**SSD 6626 - SICEEP Darling Square - Mixed Use
Residential Building within North-East Plot**

**Submission
OBJECTION**

21 November 2014

Concept proposal
parameter plan shadows
for N + SE plots

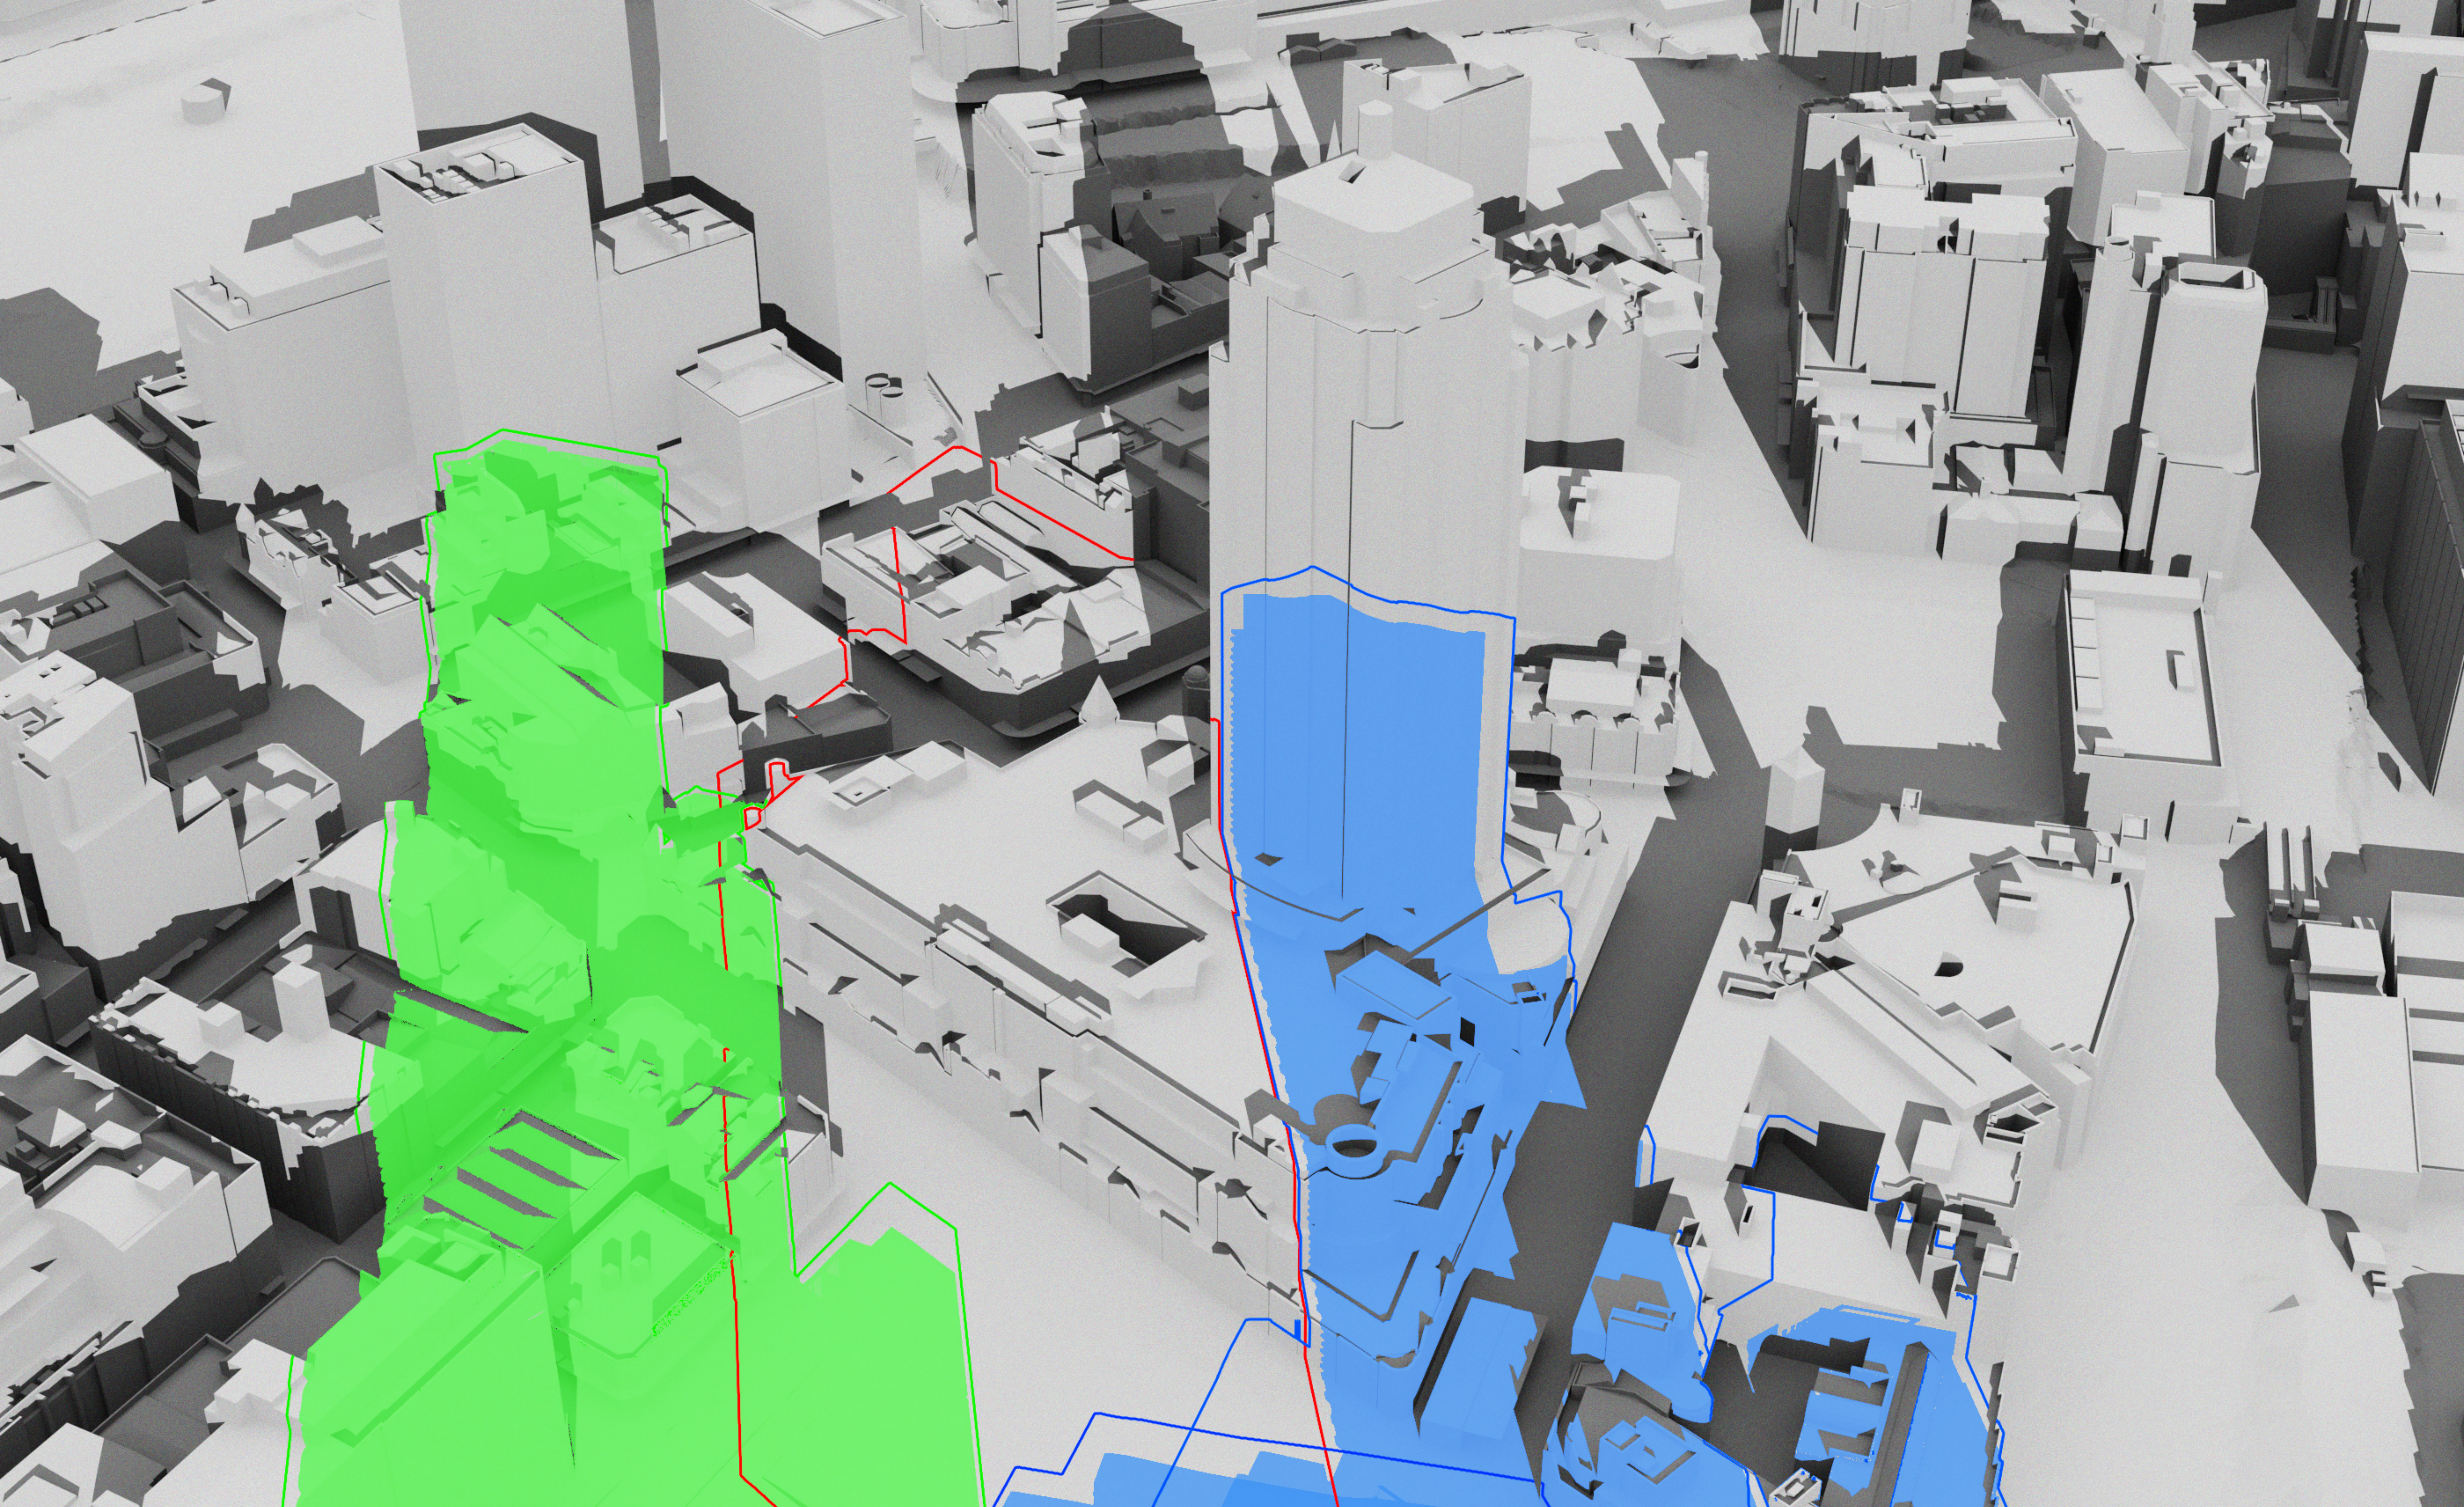
Excessive overshadowing of The Peak podium

With respect to the podium of The Peak Apartments, the EIS states that "The landscaped podium associated with The Peak Apartments will continue to receive at least two hours of solar access, ensuring compliance with the intent of the Sydney DCP 2012.". Although this statement is true, two hours is a major reduction from the existing 21 June daylight access of about six hours.

Excessive overshadowing of public open space - the new square - "Haymarket Square"

I agree with the City of Sydney's view that "excessive morning shadows are cast into the outdoor and café areas in the new square by new surrounding building edges. In order to improve morning sun access to the square in winter, it is recommended that the building heights lining the new square be reduced and the floor area relocated to the surrounding streets podium edges..." Source: City of Sydney, SSD 5878 (SICEEP) The Haymarket submission, page 34.
